Stormwater Quality Plan Information Sheet and Inspection Fee Schedule

Project Name: Wintergreen Apartments

October 19, 2021
Ron Bohannon
Tierra West, LLC
5571 Midway Park Place, NE
Albuquerque, NM 87109

**Re: Winter Green Apartments – 10932 Golf Course Rd NW.
ESC Plan Engineers Stamp Date: 10/6/2021 – A12E008D**

SB-3Pond Volume Calculation	
Area at Mid Depth	2,815 Sq. Ft.
Depth of Pond	4 Ft.
Total Volume	11,258 Cubic Ft.

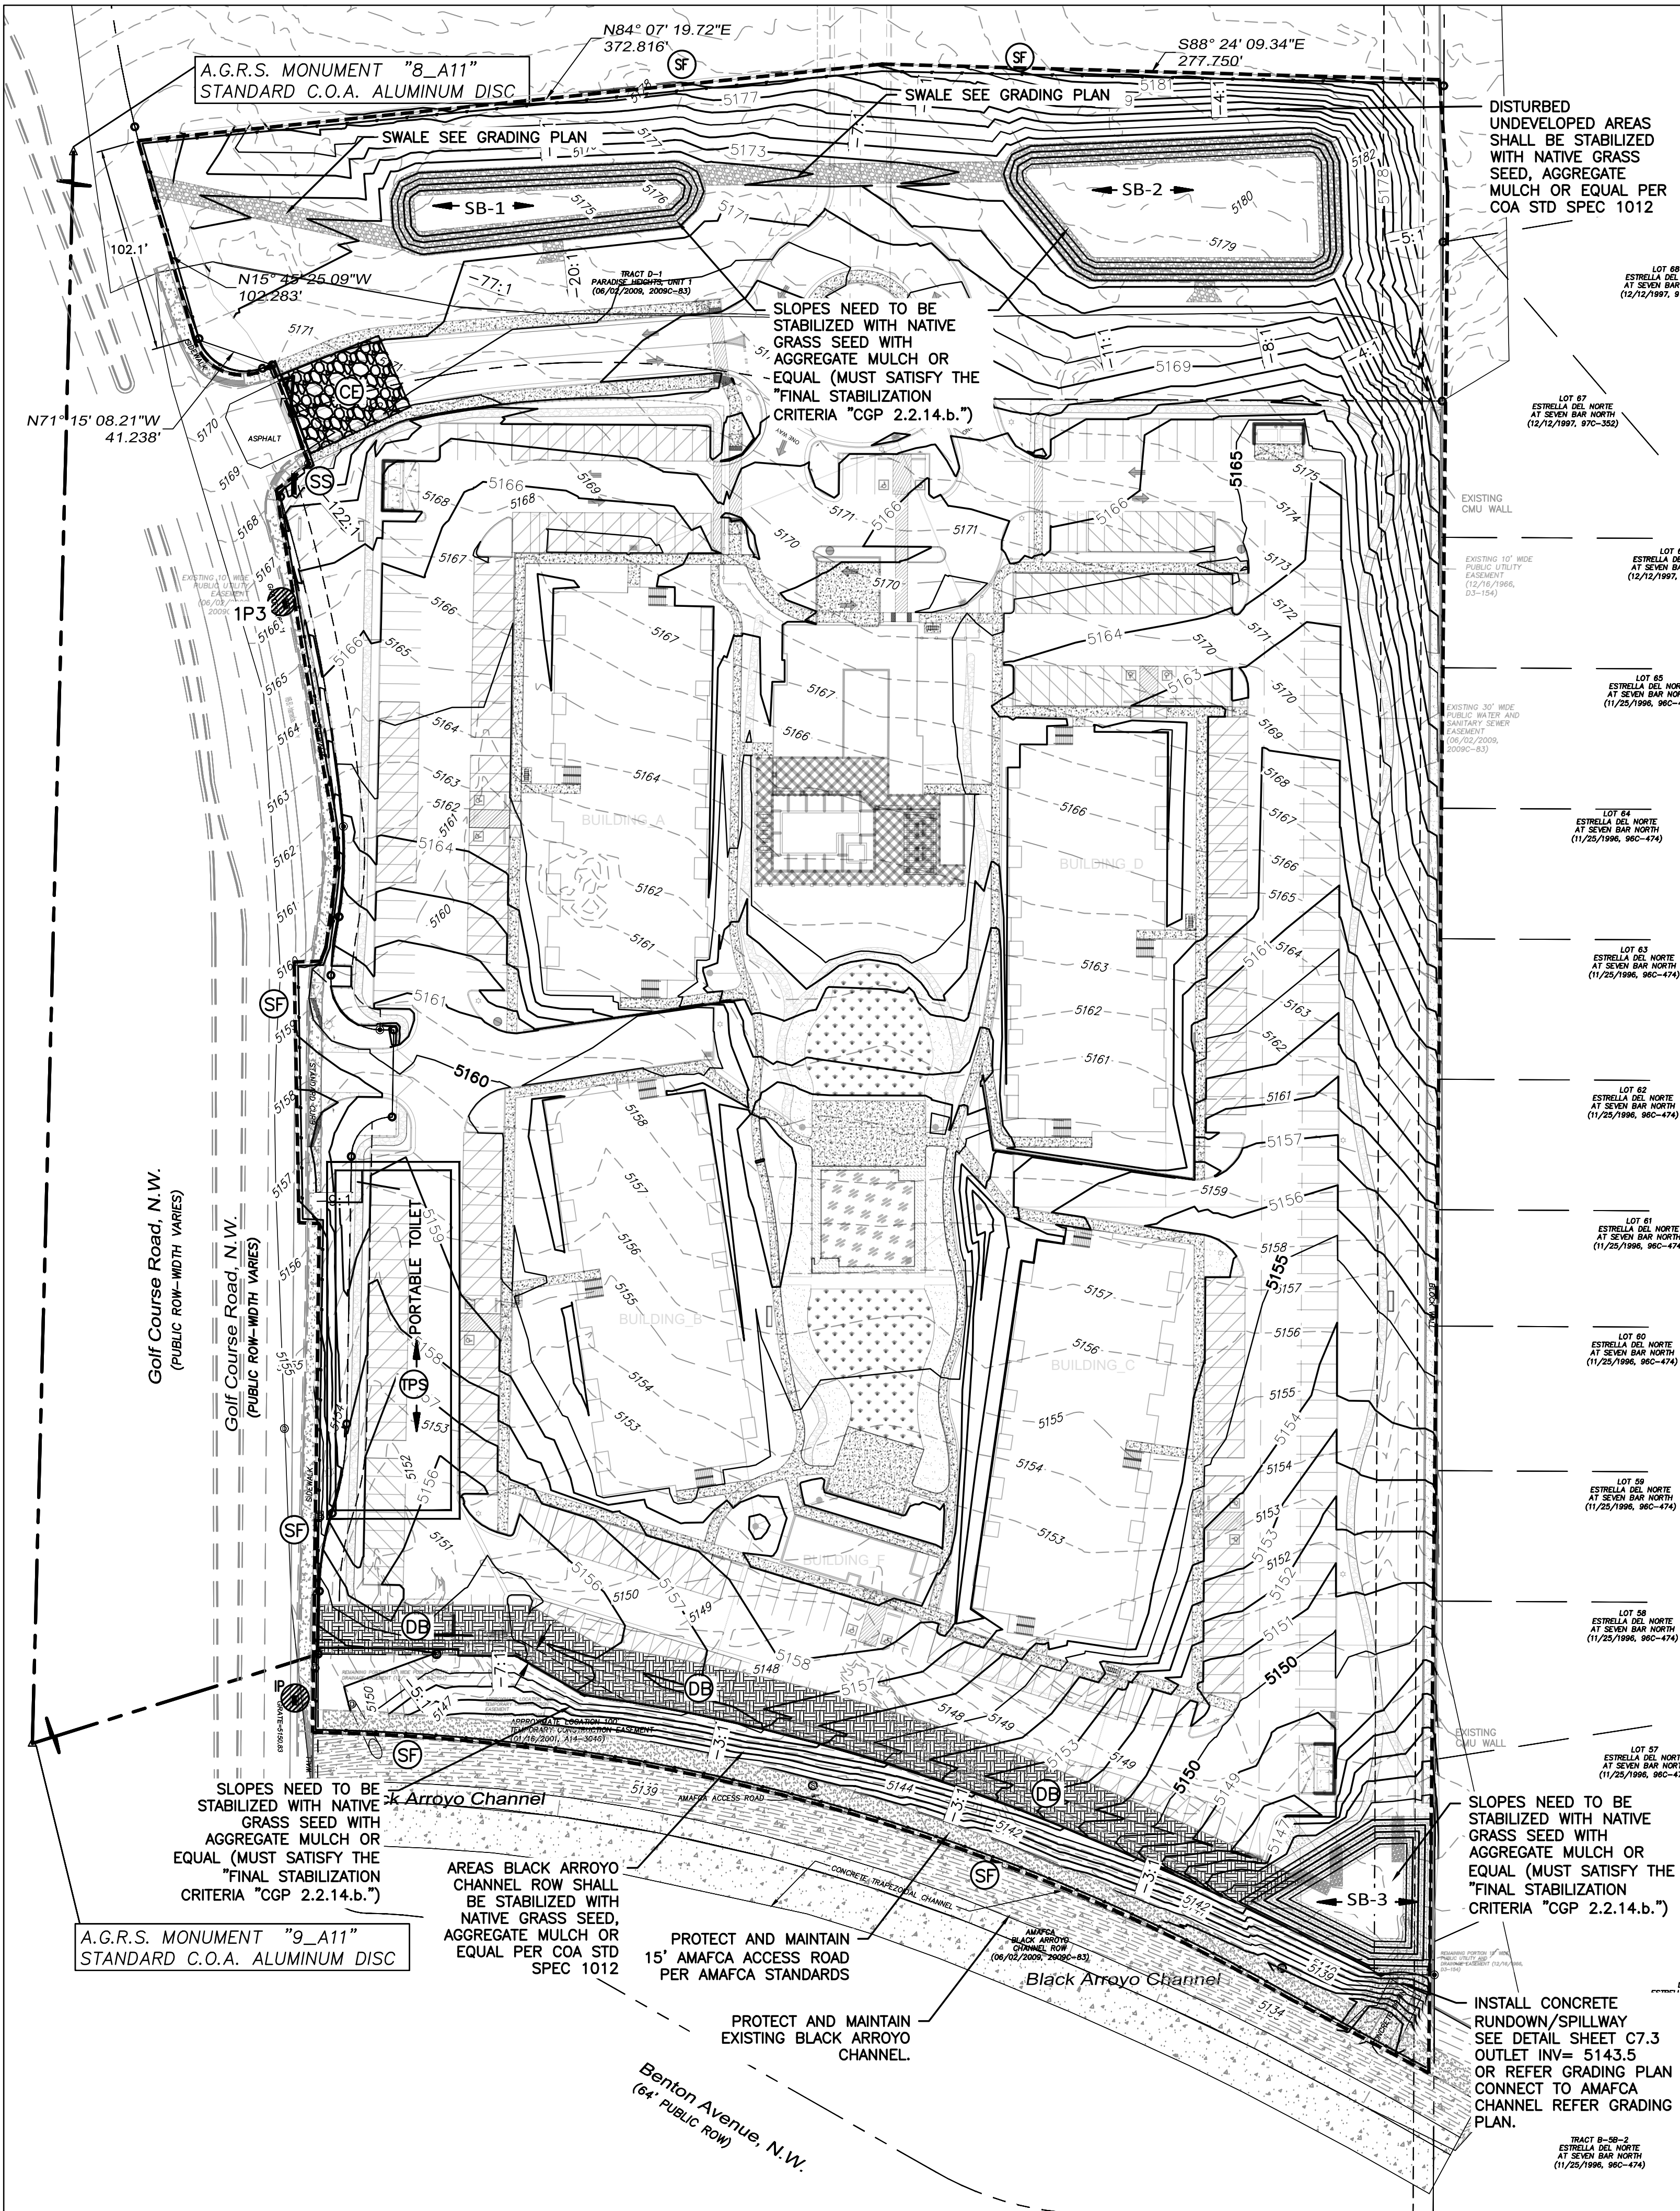
4. More detail is needed for the outlet structure at SB#3.

RESPONSE: Acknowledged, added invert elevation and structure detail.
5. Update the engineer's stamp date each time the plan is changed.
RESPONSE: Acknowledged.

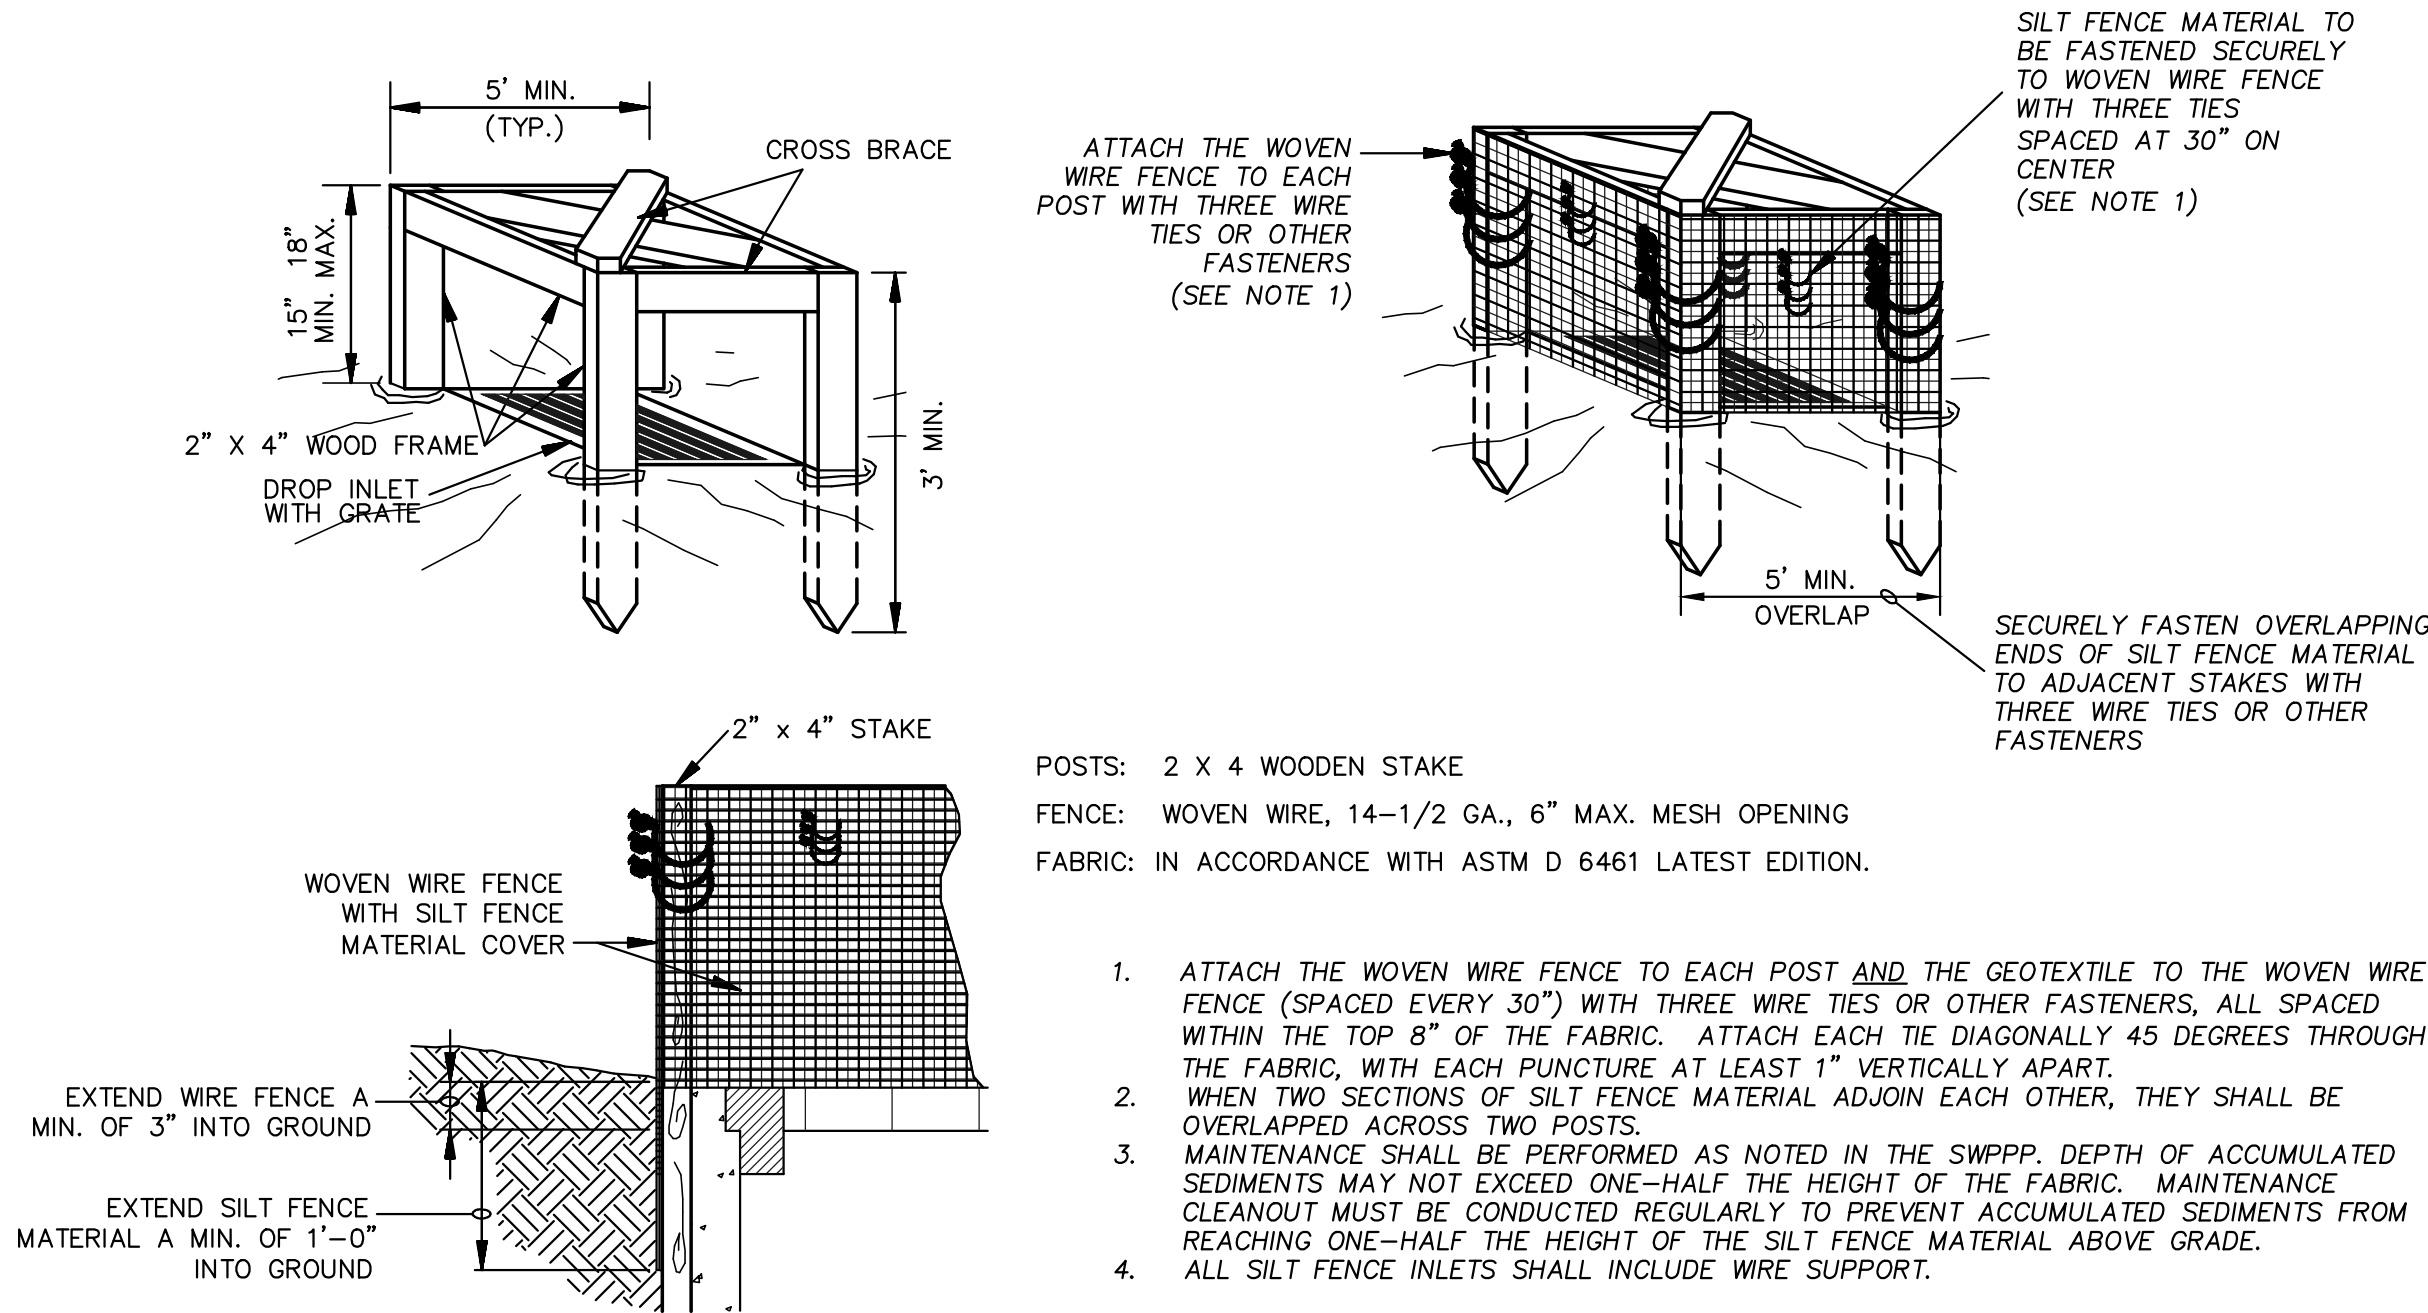
3. Stabilization measures are not identified on the Landscape Plan for the grading on the adjacent parcel to the north. Erosion Control note 7 on sheet C7.2 covers the deadlines, but General Erosion Note 'O' would be more specific and accurate if it says Temporary Cover and Final Stabilization (Part 2.2.14 (a) and (b) respectively) are to be per COA STD SPEC 1012 Native Seed with Hydromulch and Aggregate Mulch respectively.

3. Stabilization measures are not identified on the Landscape Plan for the grading on the adjacent parcel to the north. Erosion Control note 7 on sheet C7.2 covers the deadlines, but General Erosion Note 'O' would be more specific and accurate if it says Temporary Cover and Final Stabilization (Part 2.2.14 (a) and (b) respectively) are to be per COA STD SPEC 1012 Native Seed with Hydromulch and Aggregate Mulch respectively.

RESPONSE: Acknowledged, Note 'O' was updated and additional stabilization language was added to ESC plan for the north lot and AMAFCA ROW.
4. More detail is needed for the outlet structure at SB#3.
